**RE: Ladera and Unser Storage – Sector Development Plan Map Amendment, Site Plan for Subdivision, and Site Development Plan for Building Permit Project #1003274**

The purpose of this letter is to explain the modifications that have been made to the Site Development Plan for Subdivision and Site Development Plan for Building Permit for our project at the corner of Ladera Drive and Unser Boulevard. The project was approved by the Environmental Planning Commission (EPC) on August 11<sup>th</sup>, 2017.

**Conditions of Approval – 17EPC-40021 – Sector Development Plan Map Amendment**

**Conditions of Approval – 17EPC-40022 – Site Plan for Subdivision**

SITE PLAN FOR SUBDIVISION

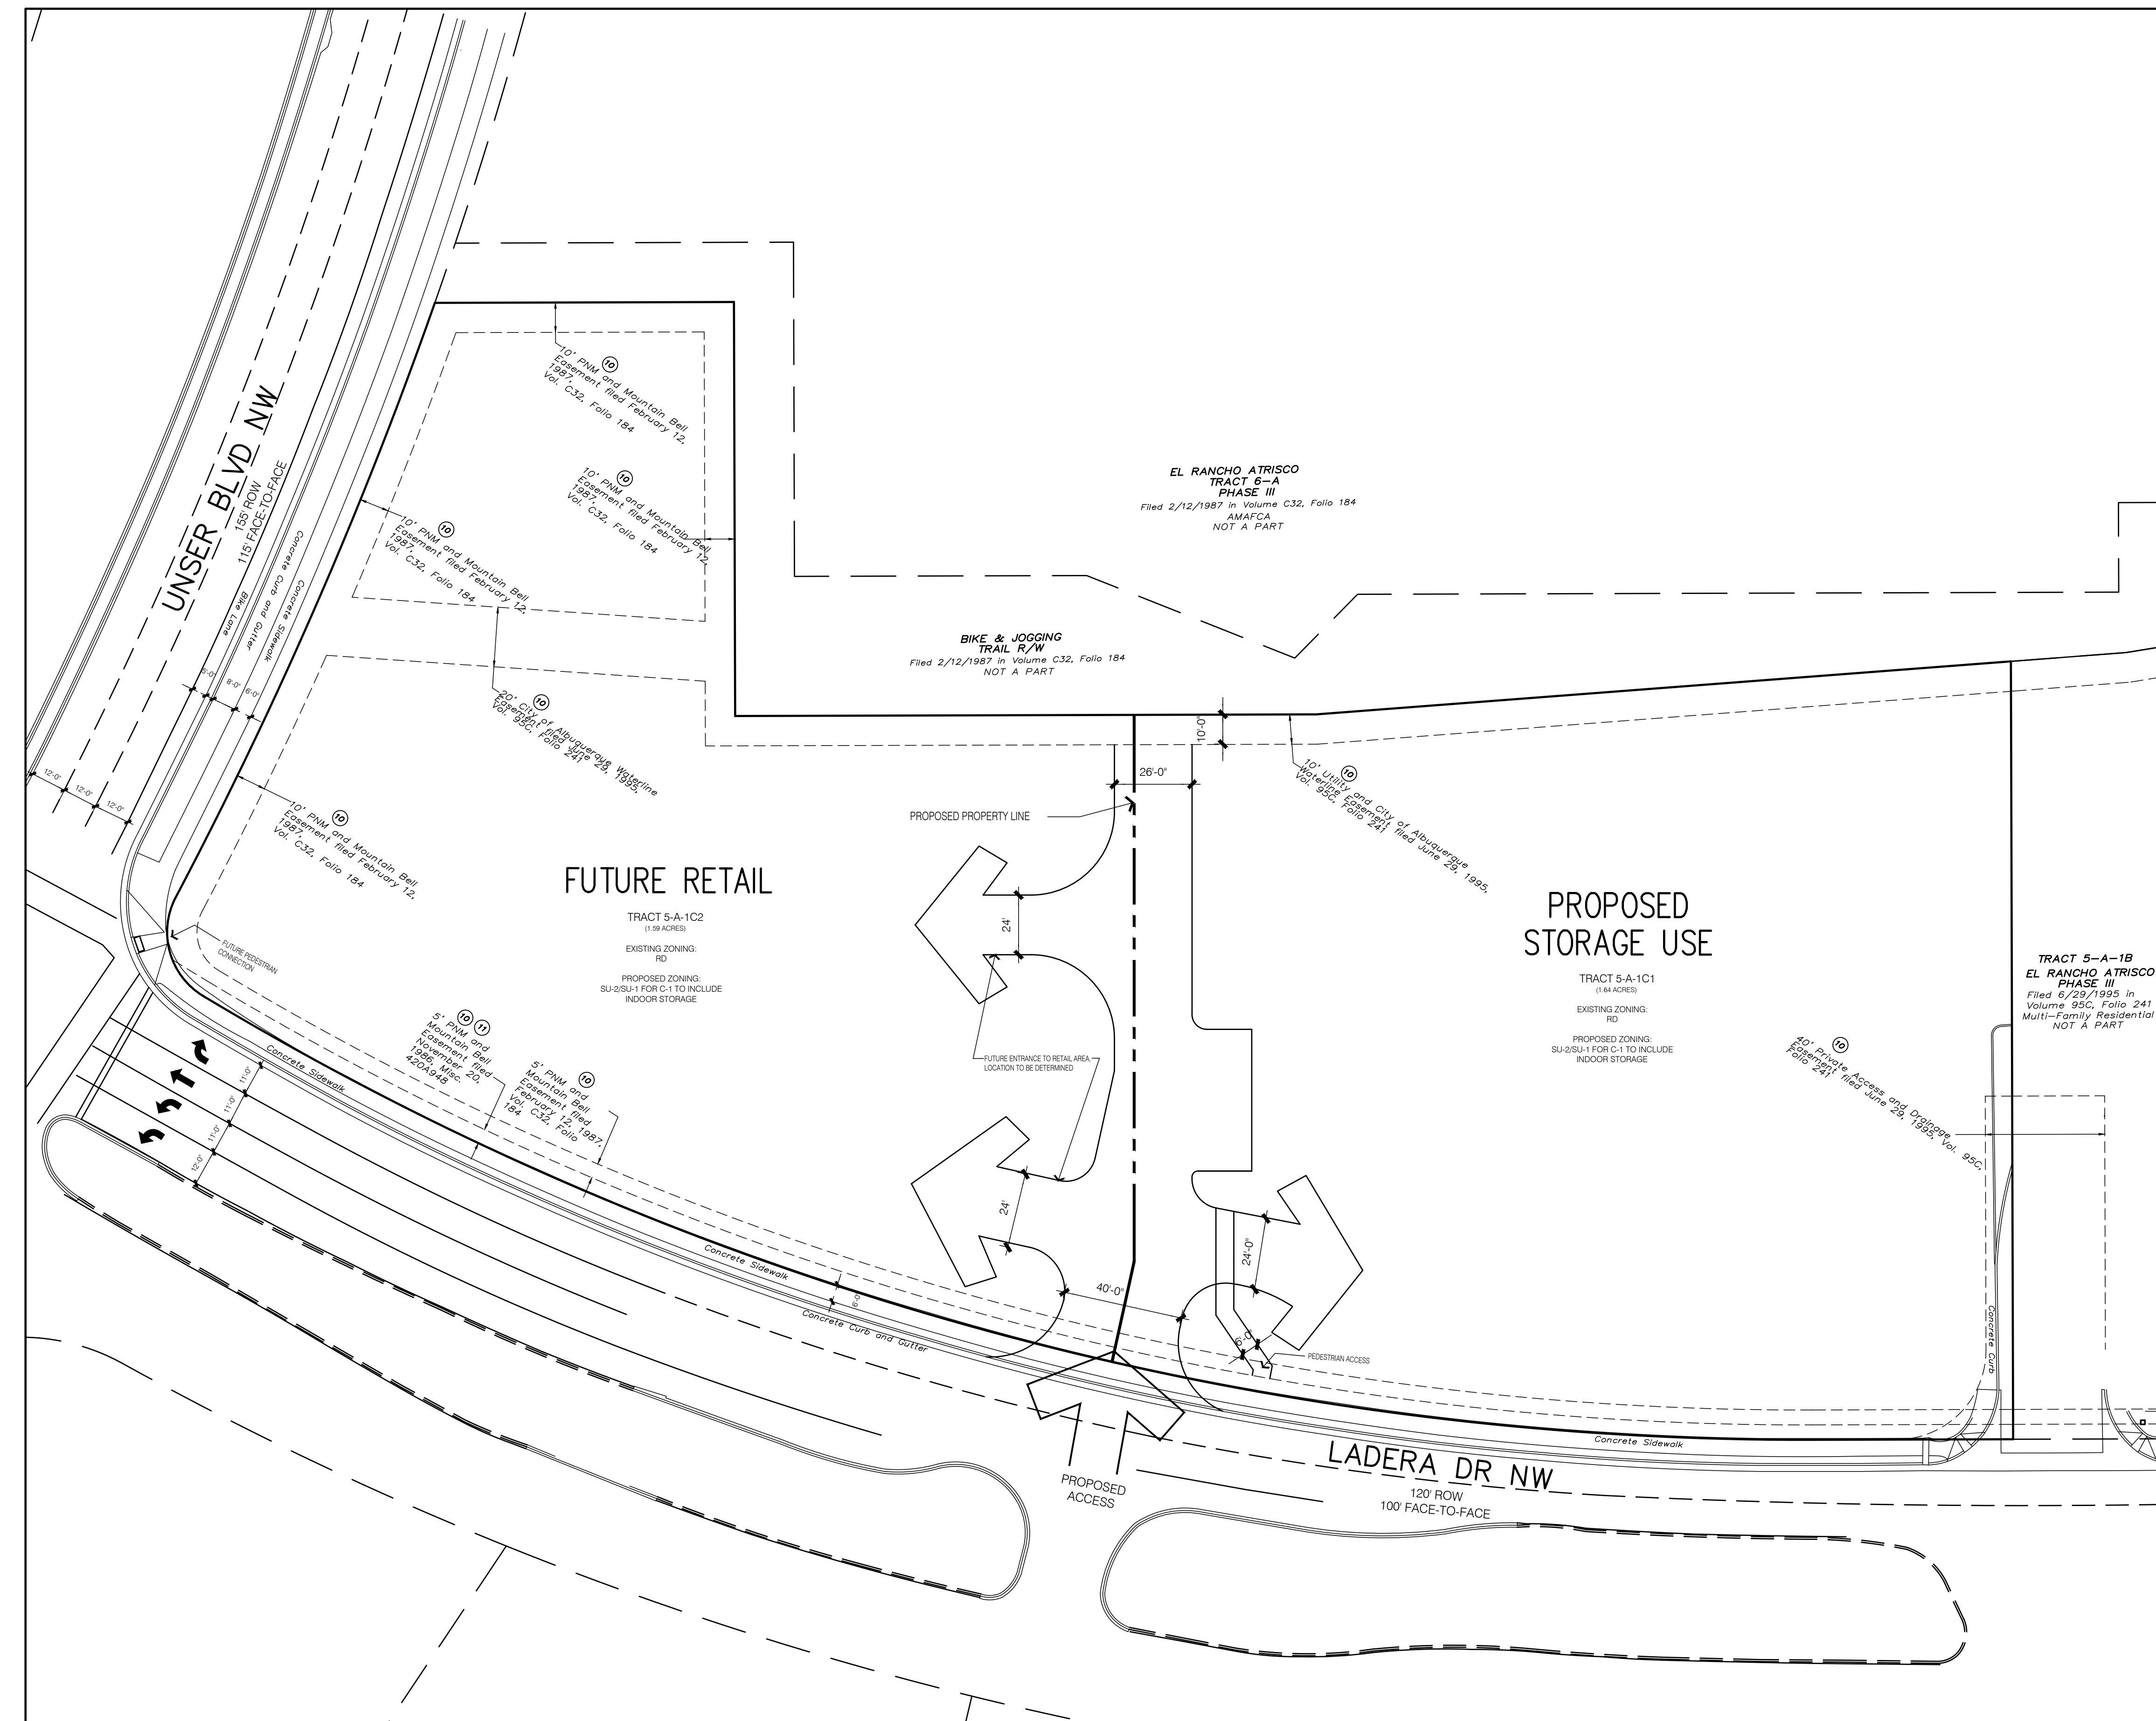
3. On Site Plan for Subdivision, revise the statement "Signage to be under a separate permit per C-1 regulations." to "Signage to be under a separate permit per C-1 regulations and the Unser Boulevard Design Overlay standards which limits free-standing signs to one per street frontage (Ladera Drive NW and one on Unser Boulevard NW) and limits wall signs to one per facade."

4. On Site Plan for Subdivision, add the statement "Future development will exclude two permissive uses: Gas Station and Residential" under the statement that starts with "Zoning:..."

*This statement has been revised. Please see first sheet of the Site Plan for Subdivision.*

*The excluded permissive uses have been added to the zoning description on the first page of the Site Plan for Subdivision.*
